DEVELOPMENT REVIEW BOARD
SUPPLEMENTAL SUBMITTAL

PROJECT NO. 2022-006547

Application No. SI-2022-00216

RE: Panda Express – S8-22-D8582
10126 Coors Blvd. NW
Albuquerque, NM 87114
RE: DRB Planning Review – 1st Resubmittal
DRB Project Number: 2022-006547
App. Number: SI-2022-00216

HARDSCAPE DETAILS II

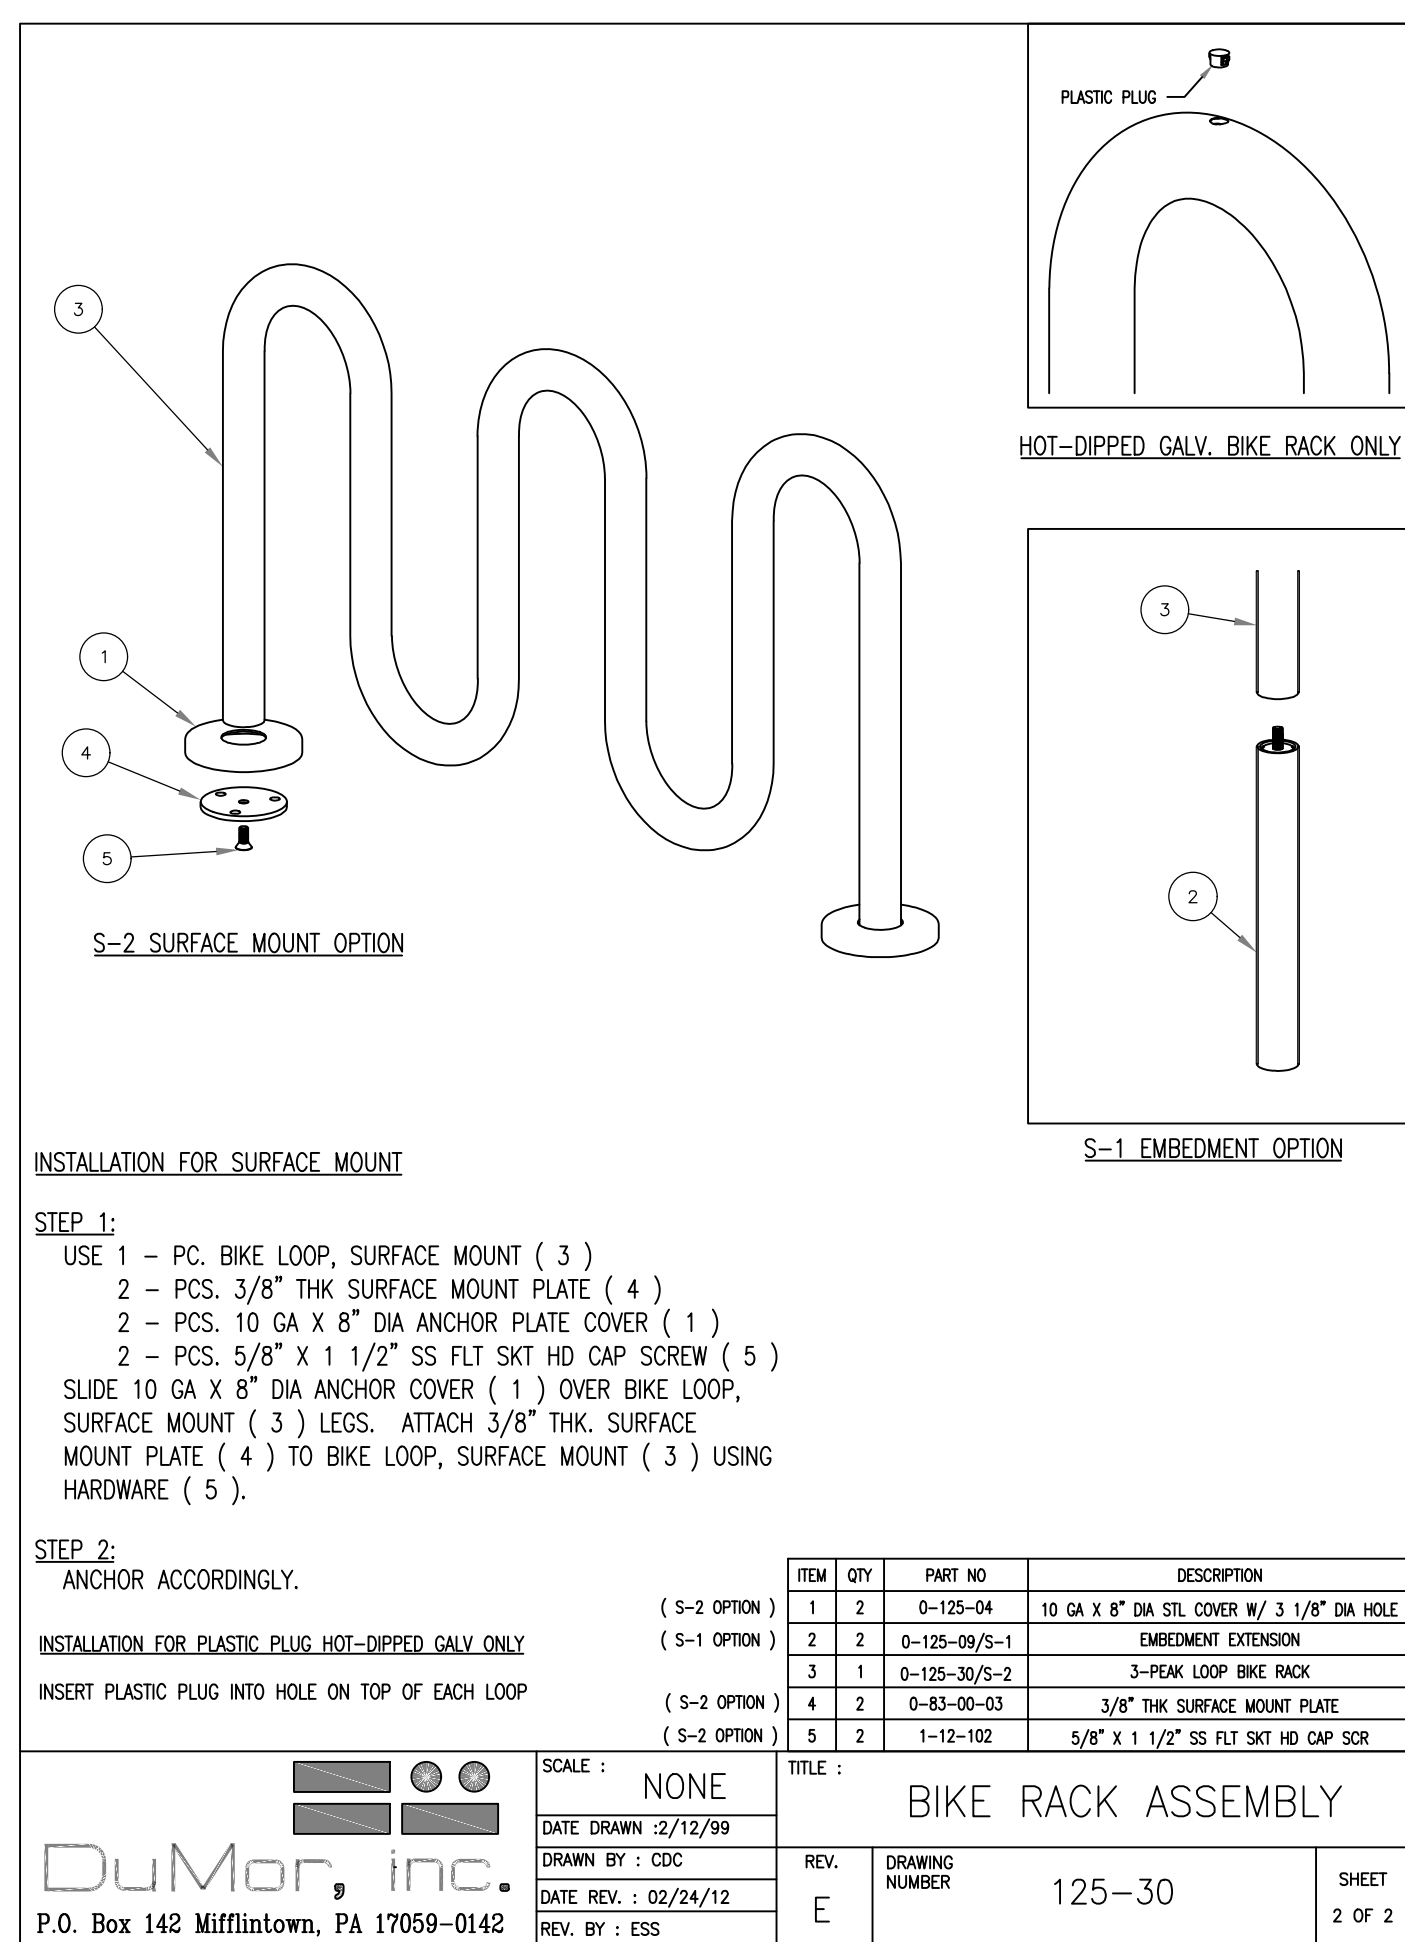
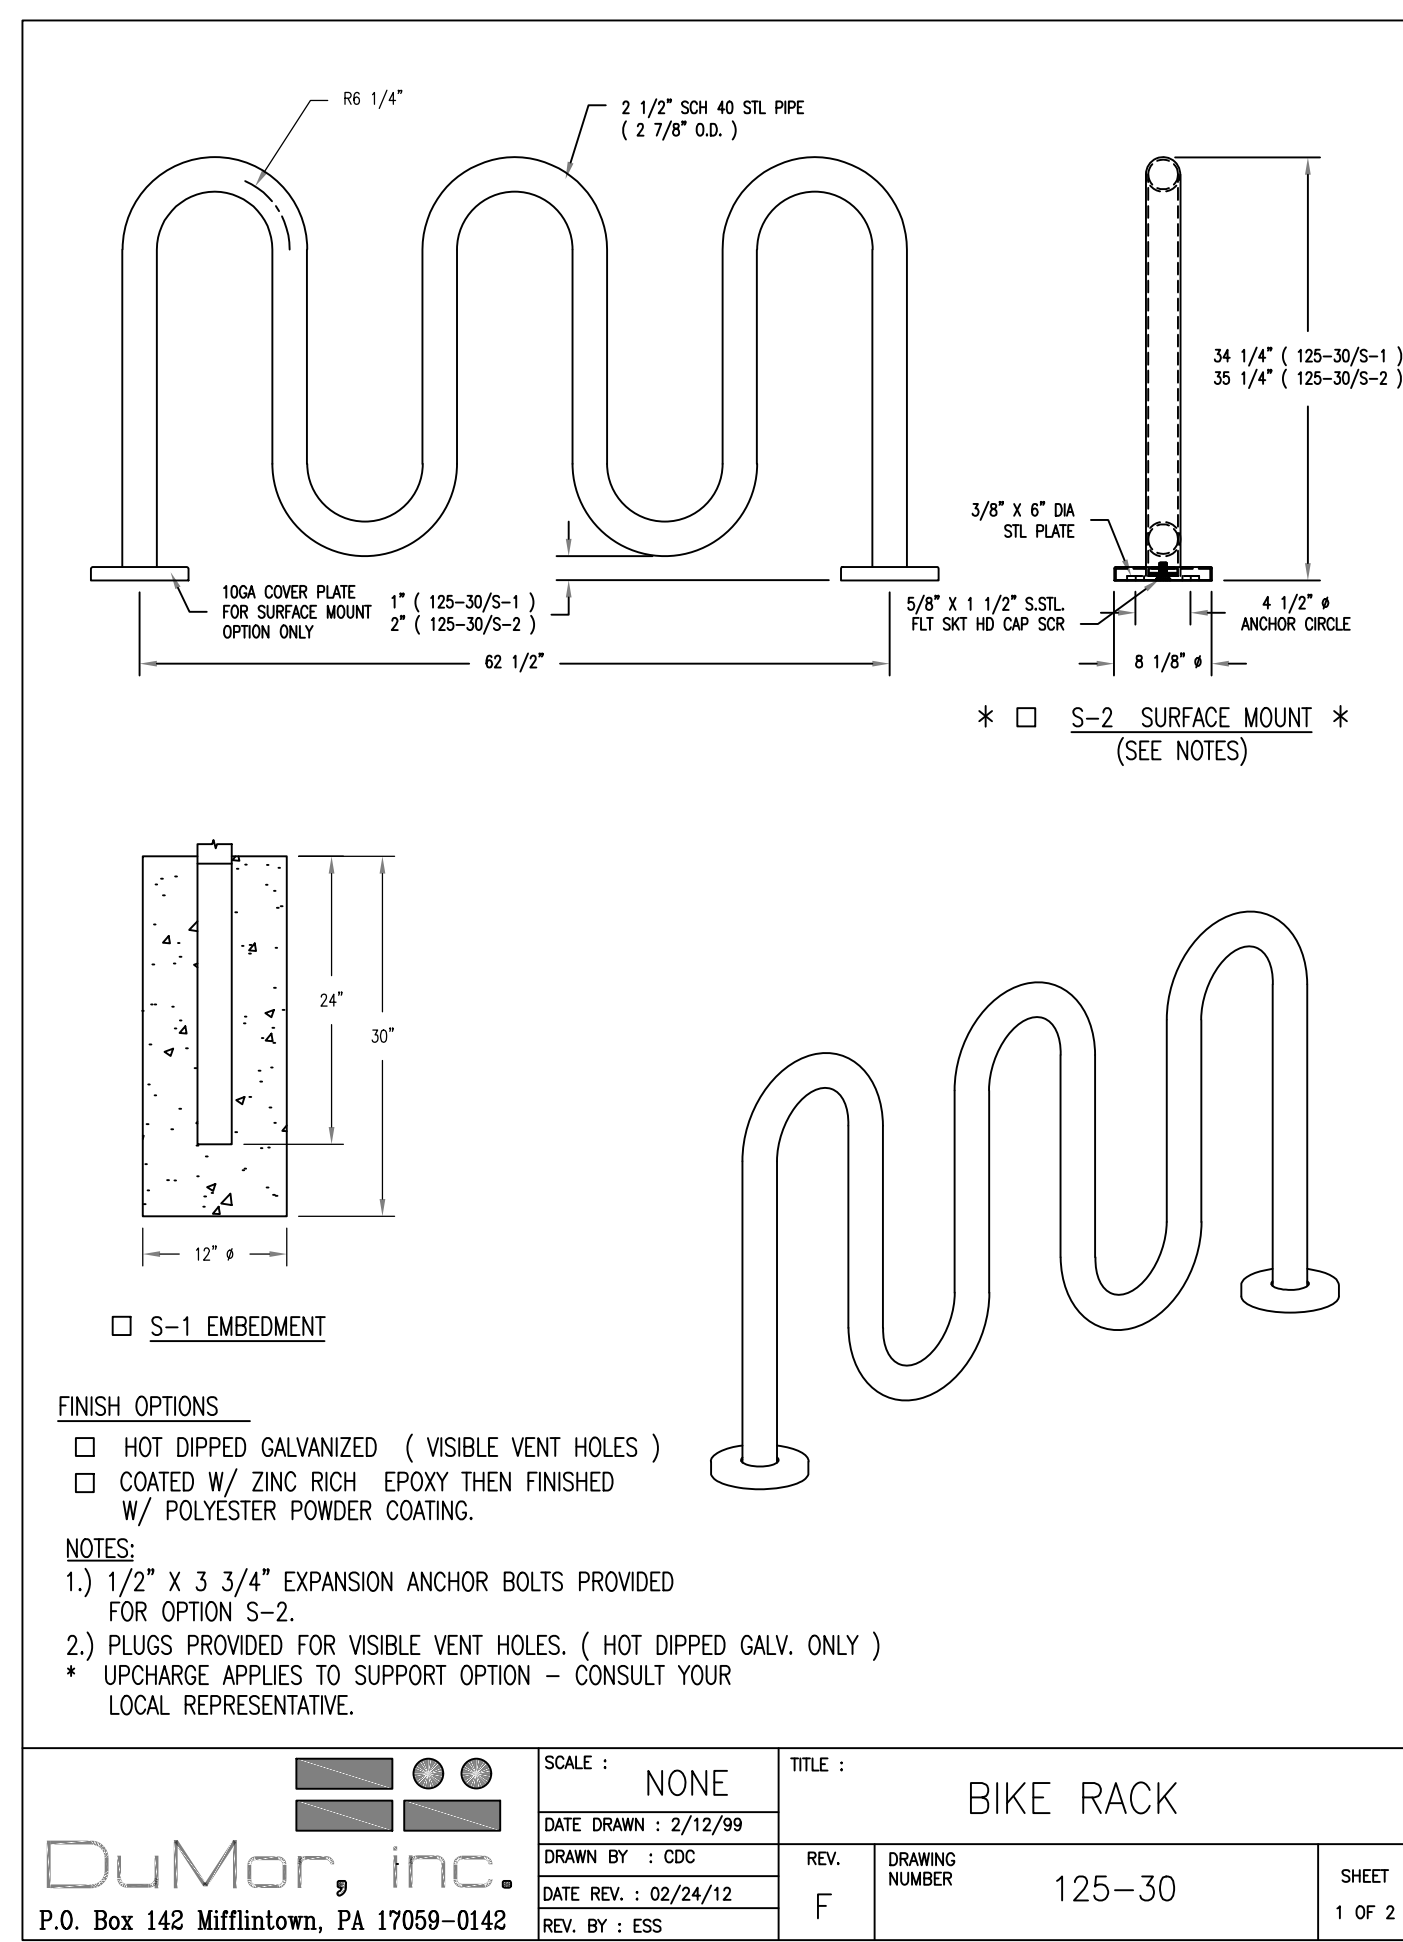
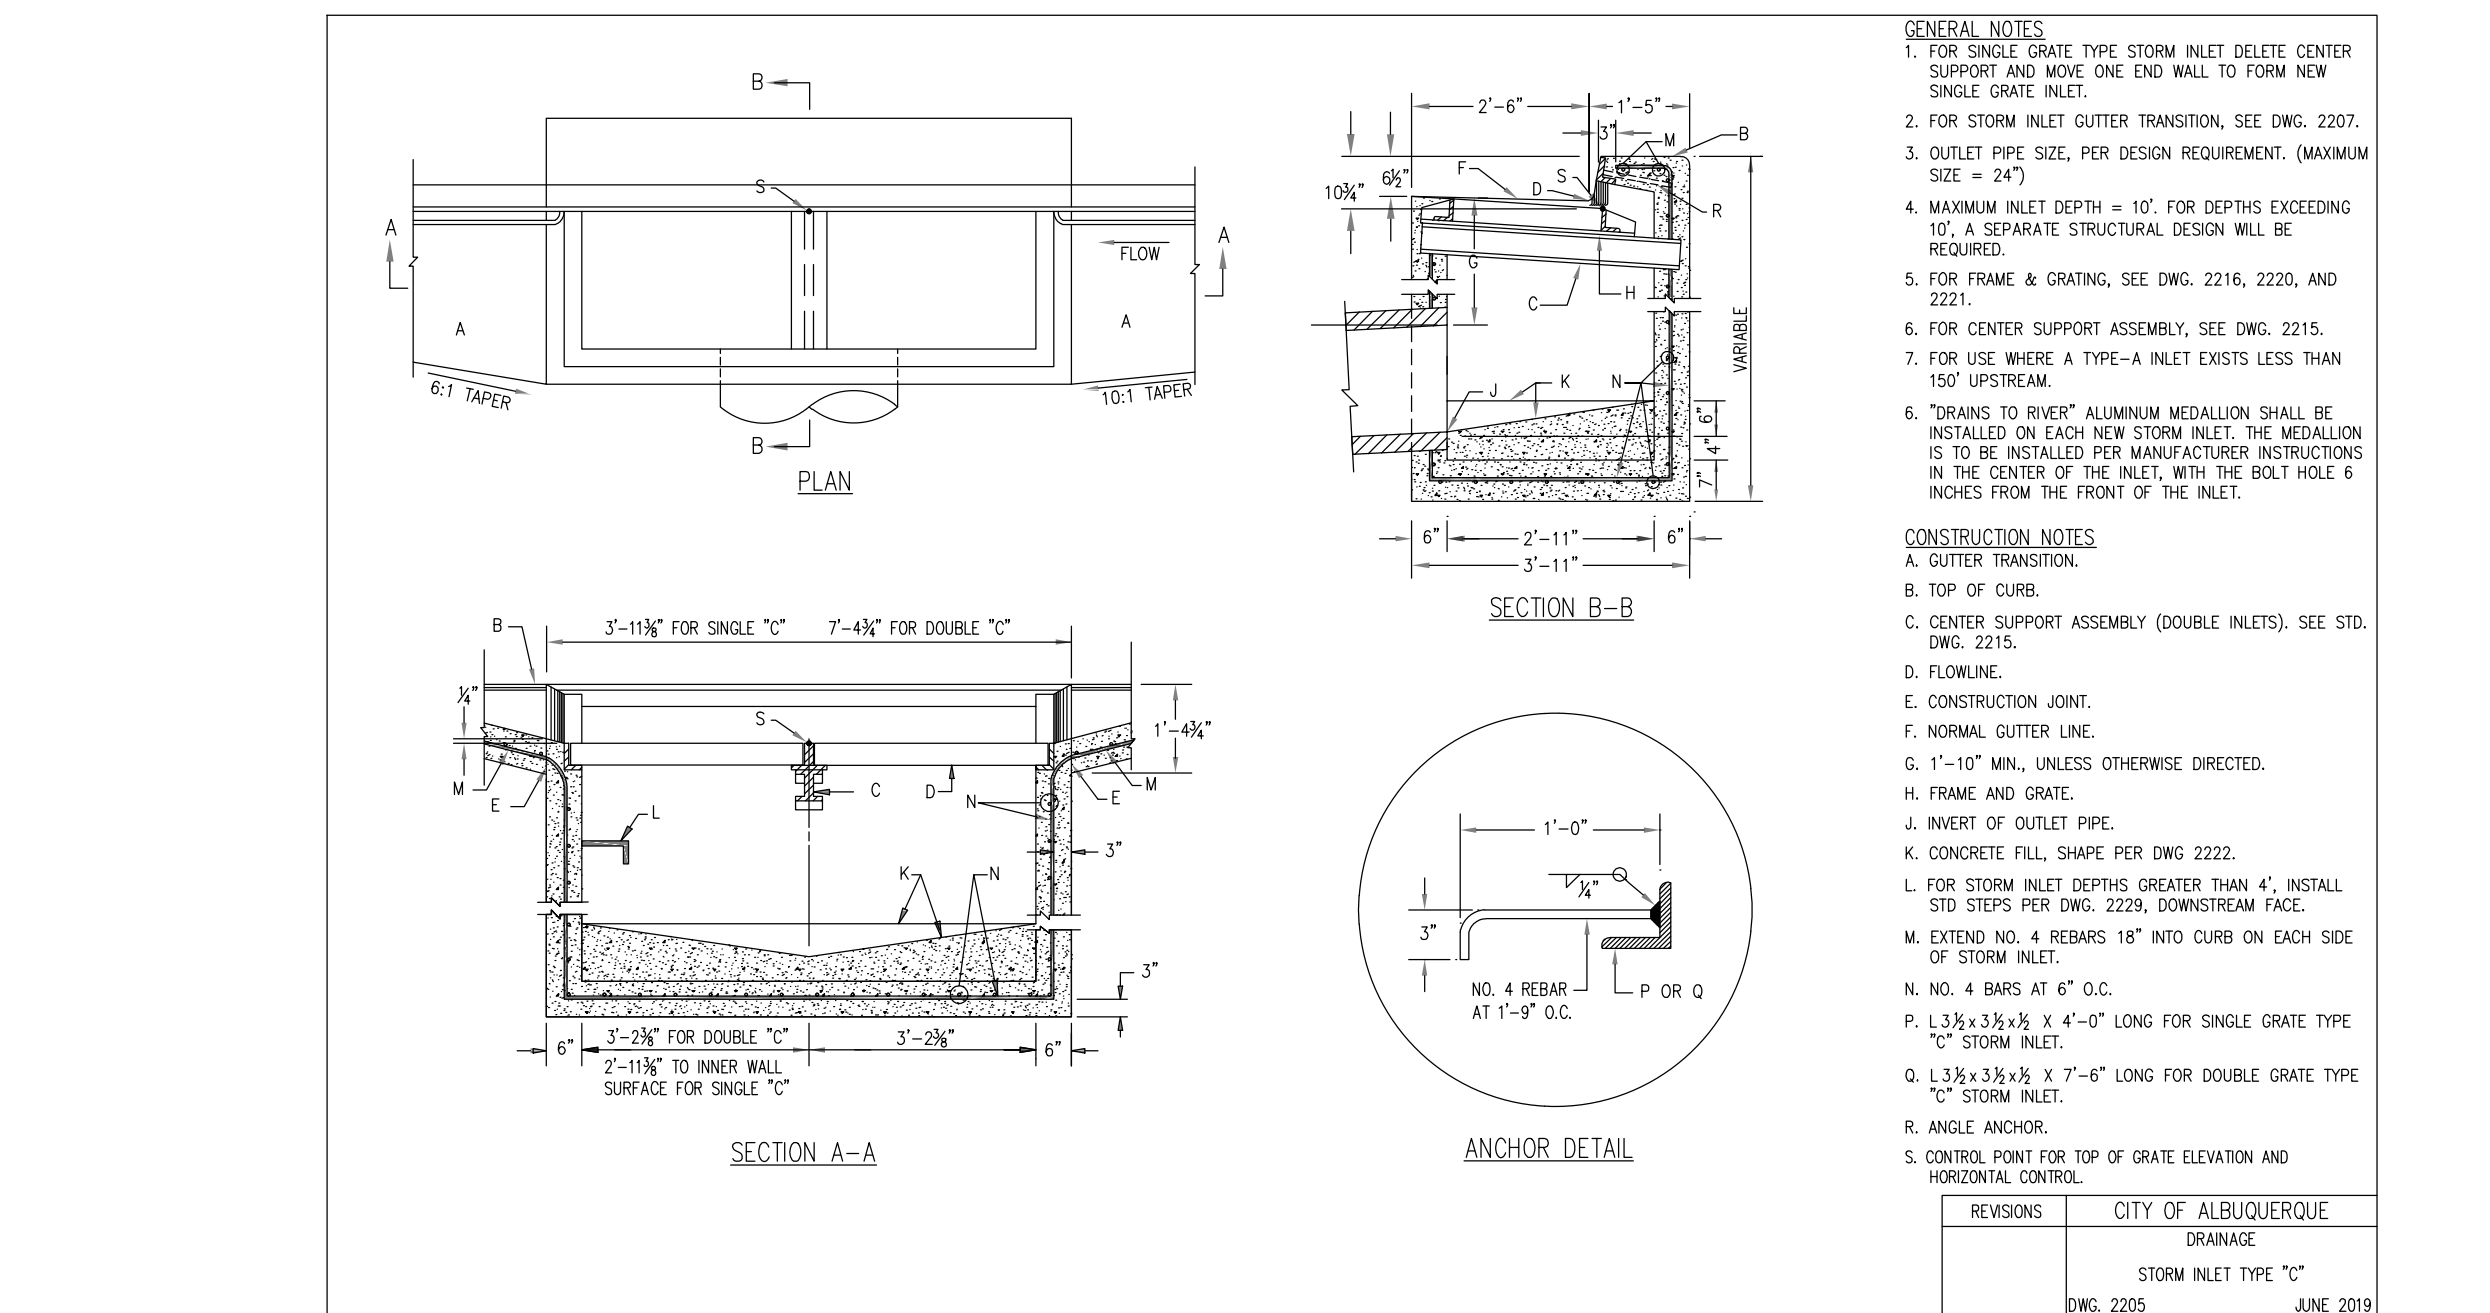
11. Motorcycle and bicycle parking details are needed. Provide these required spaces on the plan. Follow DPM requirements for the bike rack details.

Response: Bicycle parking per Figure 7.4.115 of DPM, specs per architectural plan. Motorcycle parking detail per Figure 7.4.116 of DPM
